Date: 7 March 2024
Our ref: GOOD/3004864.3
Your ref: TR030008
DDI: [REDACTED]
e-mail: [REDACTED]@bcplaw.com

**Planning Act 2008 and the Infrastructure Planning (Compulsory Acquisition) Regulations 2010 ("CA Regulations")
Application by Associated British Ports ("the Applicant") for an Order Granting Development Consent for the Immingham Green Energy Terminal ("IGET") and Associated Development ("AD")
Applicant's request for advice on consultation relating to proposed Change Request
Application Reference: TR030008**

FIGURE TITLE
Site Boundary & Works Plans Changes between DCO Application (September 2023) & Change Application (March 2024)
Sheet 1 of 2

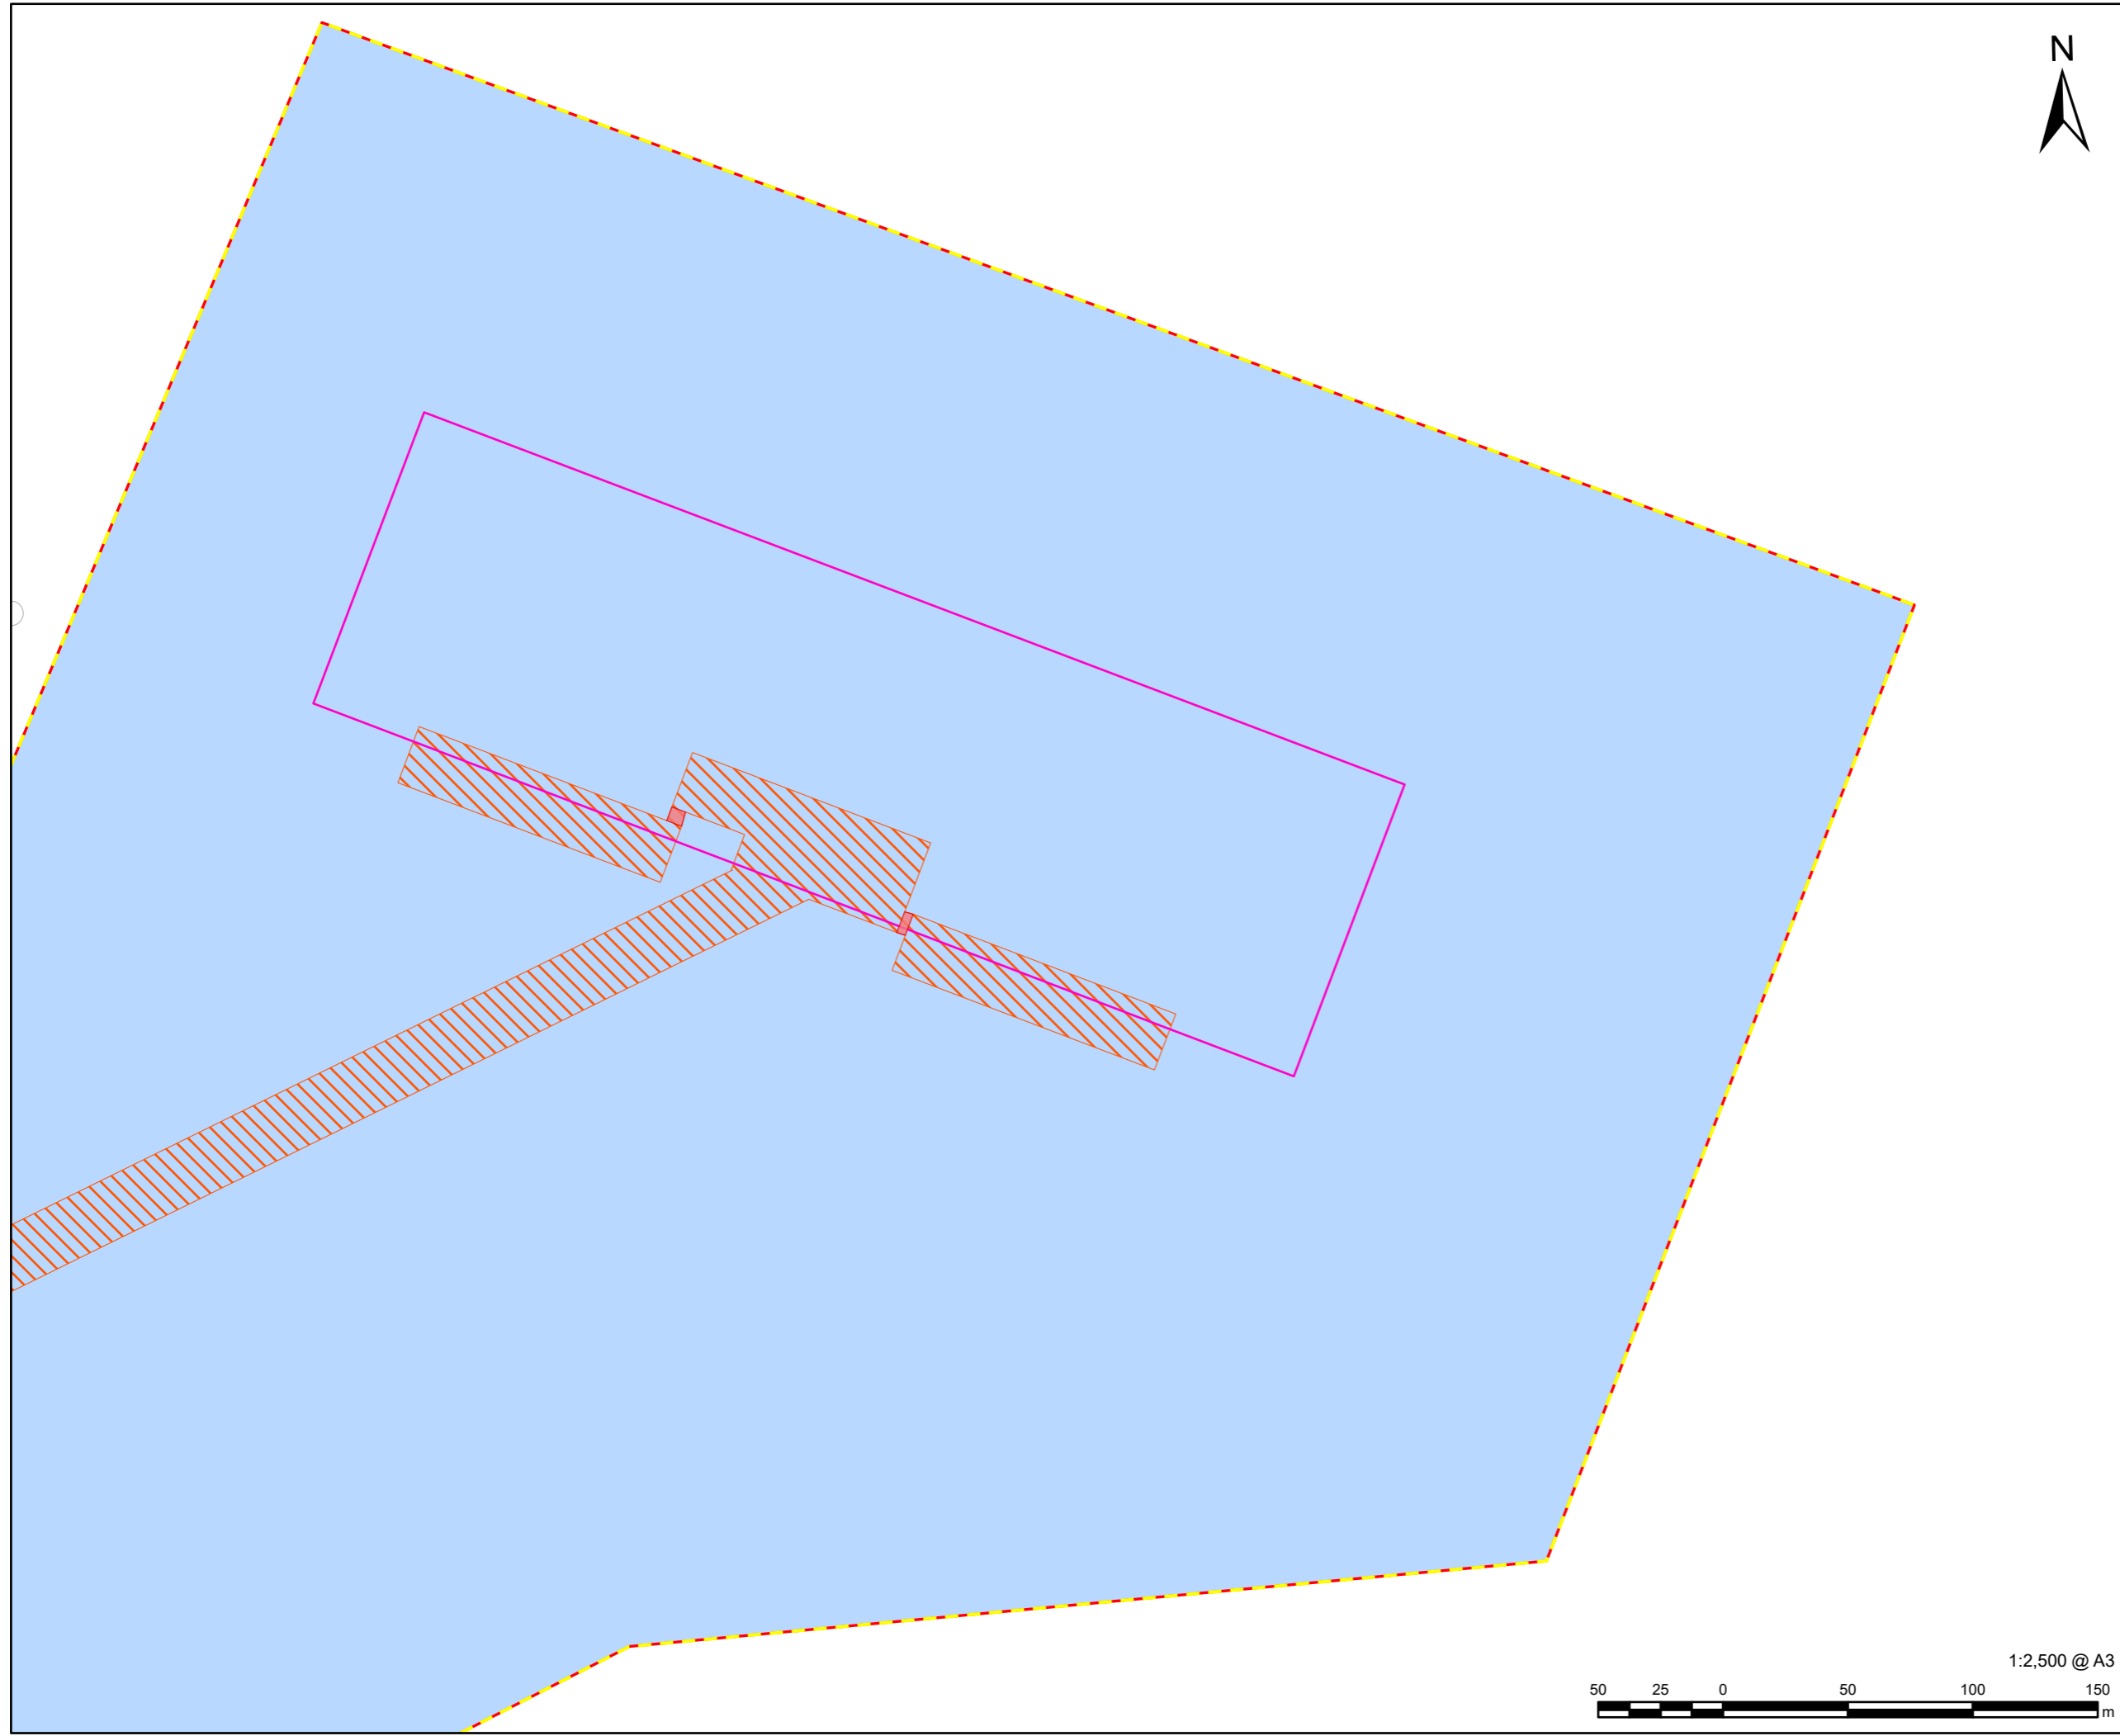
- 1.2.4 **Change 4:** addition of detail to Work No. 1a in the Works Plans [**APP-002**] to show the walkways linking the Jetty Head to the Mooring Dolphins. These walkways are already described at paragraph 1(a)(ii), Schedule 1 and at Paragraph 3(2)(a)(ii) of Schedule 3 of the dDCO [**PDA-004**].

- 1.3 Changes 1 and 2 do not affect the size of Work No. 1a therefore Work No. 1a in the Works Plans [**AS-002**] remains as previously submitted, save for the addition of Change 4. The visual addition of the walkways in the Works Plans (referred to as Change 4 above), and the proposed relocation road access "AB" and small area of additional land to be included within the Application site forming Change 3, are shown indicatively in the attached plans at Appendix 2. The first page of Appendix 2 gives an overview of the changes in the context of the Project, and details of Change 4 are shown indicatively on the second page of the plans, and details of Change 3 are shown on the third page of the plans.

FIGURE TITLE
Site Boundary & Works Plans Changes between DCO Application (September 2023) & Change Application (March 2024)
Sheet 2 of 2

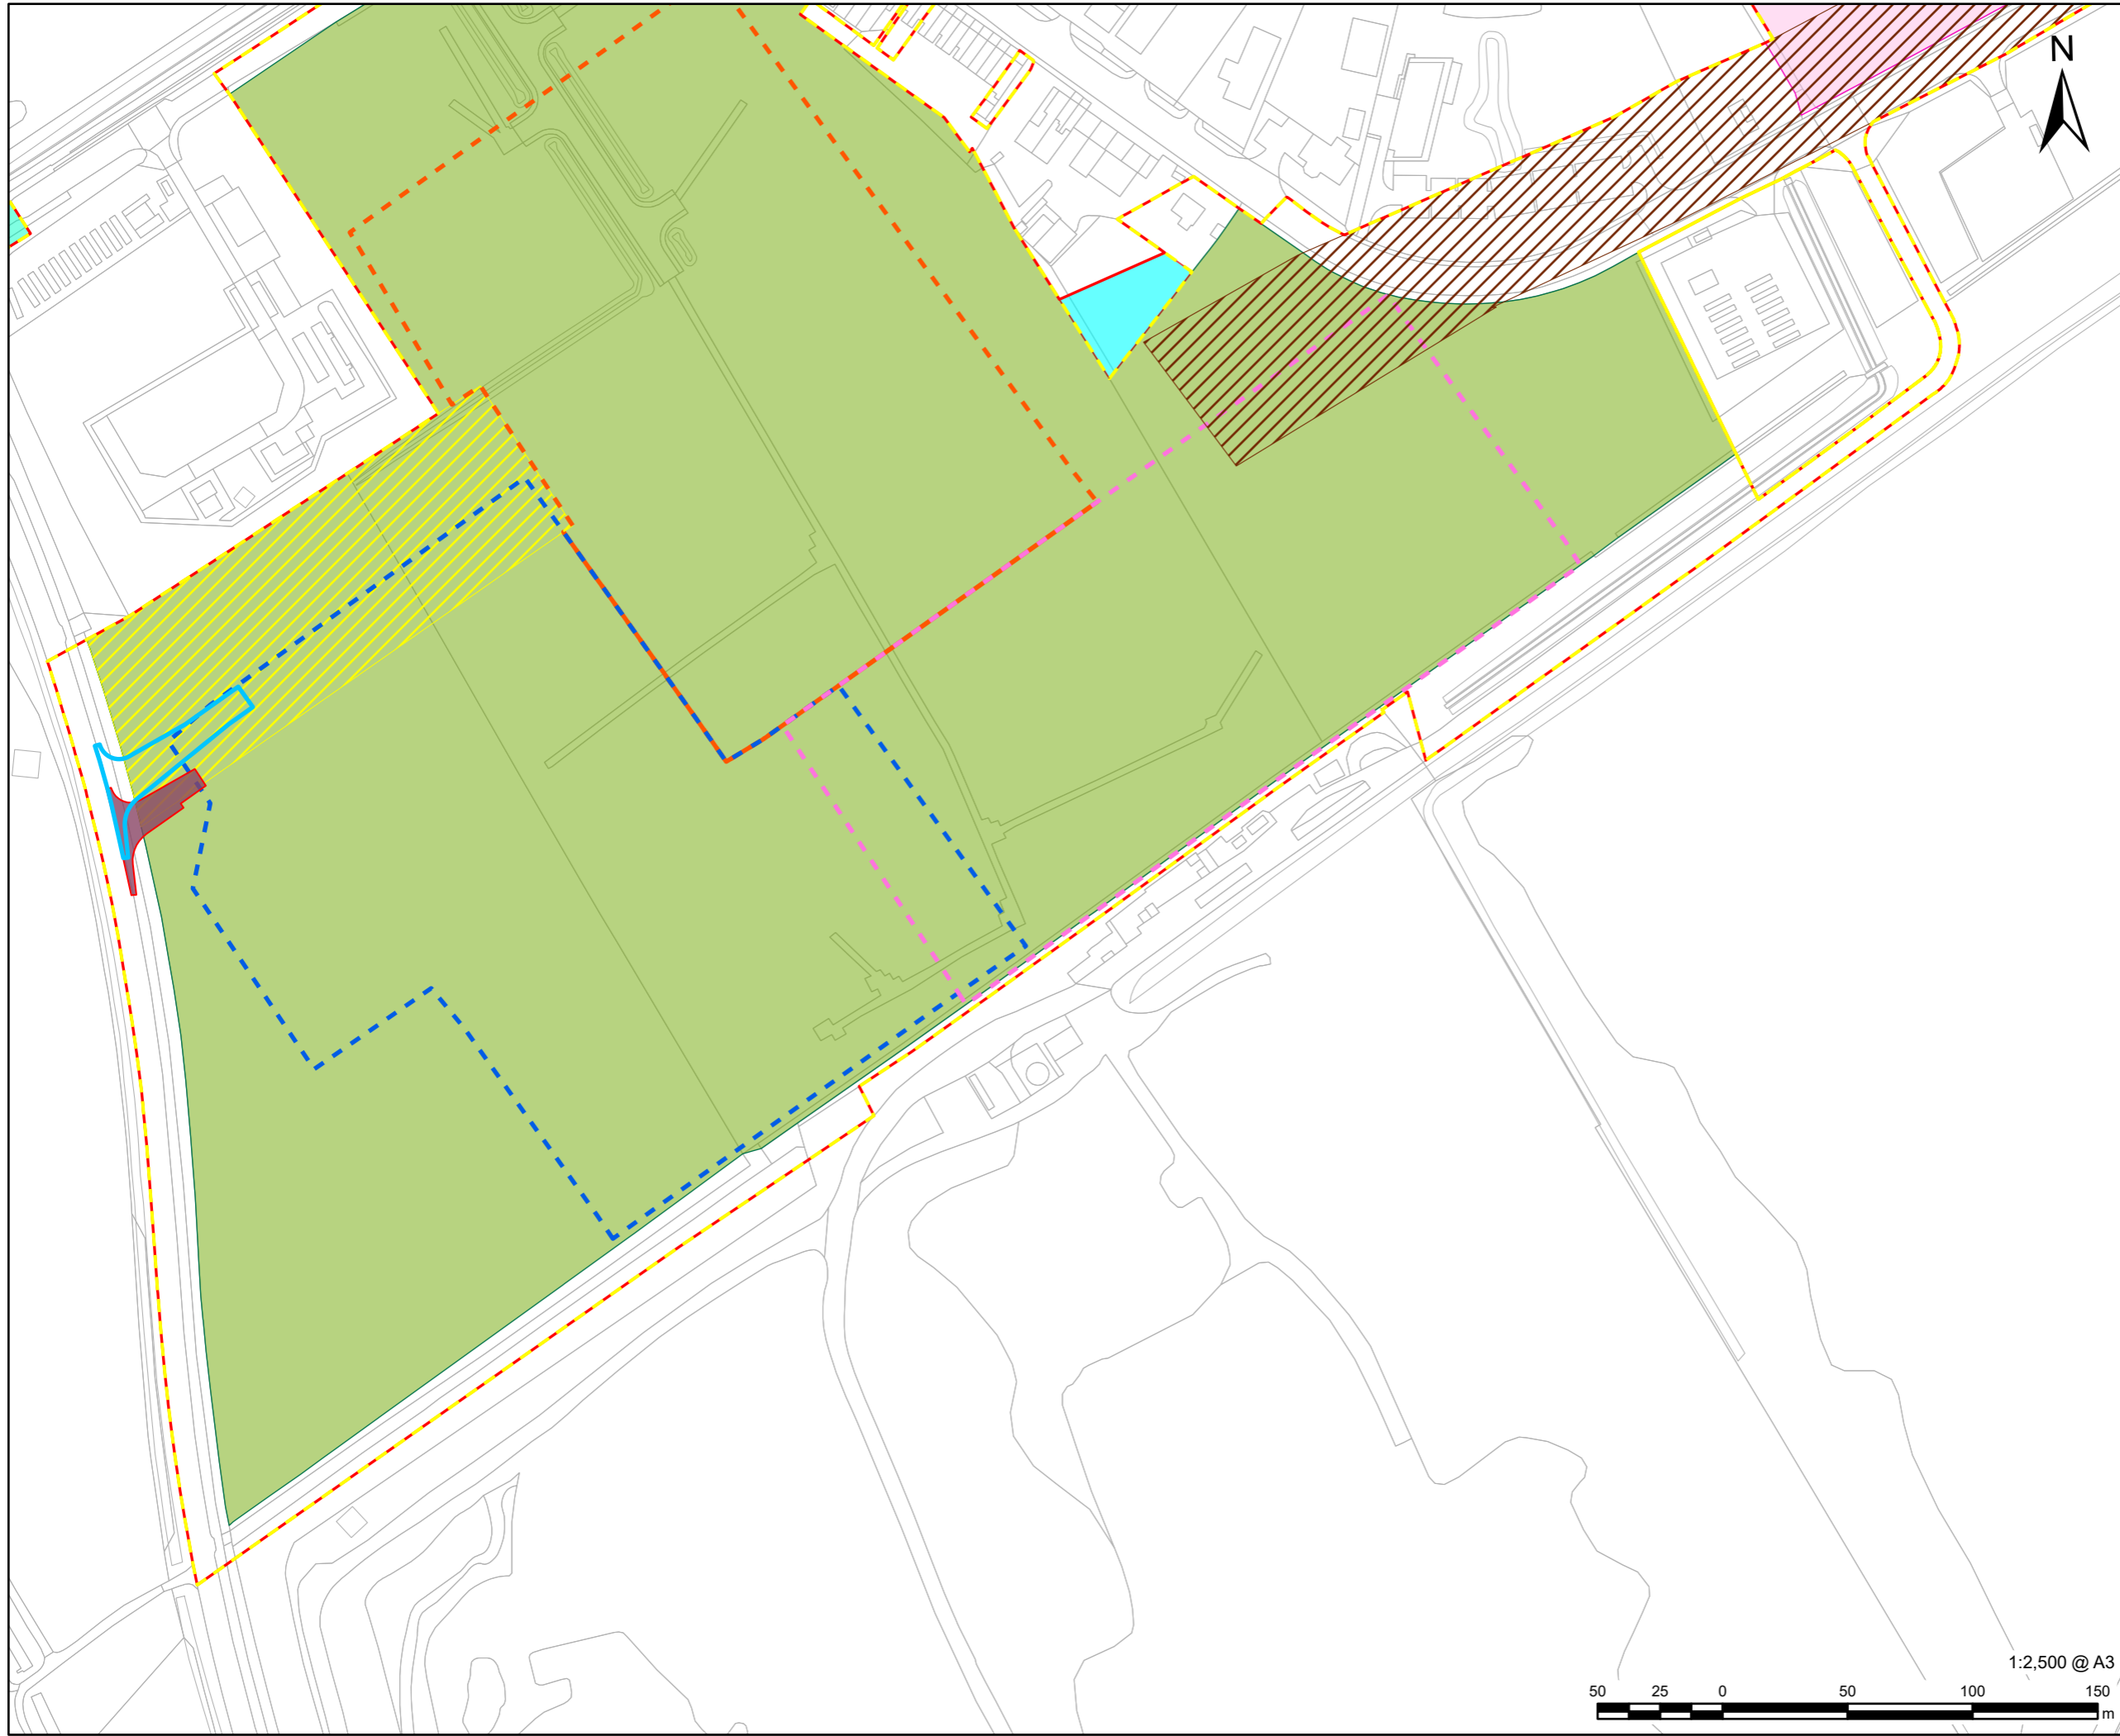
- 1.2.3 **Change 3:** change to the likely detailed layout of the Associated Development within Work No. 7 (which is not for approval at this stage). Cadent Gas's high-pressure gas pipeline crosses the Application site within Work No. 7. Following recent engagement with Cadent Gas (as highlighted in its Relevant Representation [**RR-002**]), it was identified to the Applicant that the activities which may take place in proximity to the high-pressure gas pipeline will be more restricted than originally anticipated. As a result, the proposed Development within Work No. 7 will need to move 10-15m. to the north of the gas pipeline. The likely consequences of the shift are:

- (a) that the location of the permanent road access to Work No. 7 labelled "AB" on the Street Works and Accesses Plan [**APP-016**] will need to change by moving approximately 10-15 metres to the north; and

- (b) that a small area of additional land will be required on a temporary basis during the construction period to accommodate the laydown of the pipeline sleeve ahead of its installation as part of Work No. 6. Although the need for additional temporary possession powers does necessitate a minor extension to the Application site boundary, the Applicant is not seeking any additional powers of compulsory
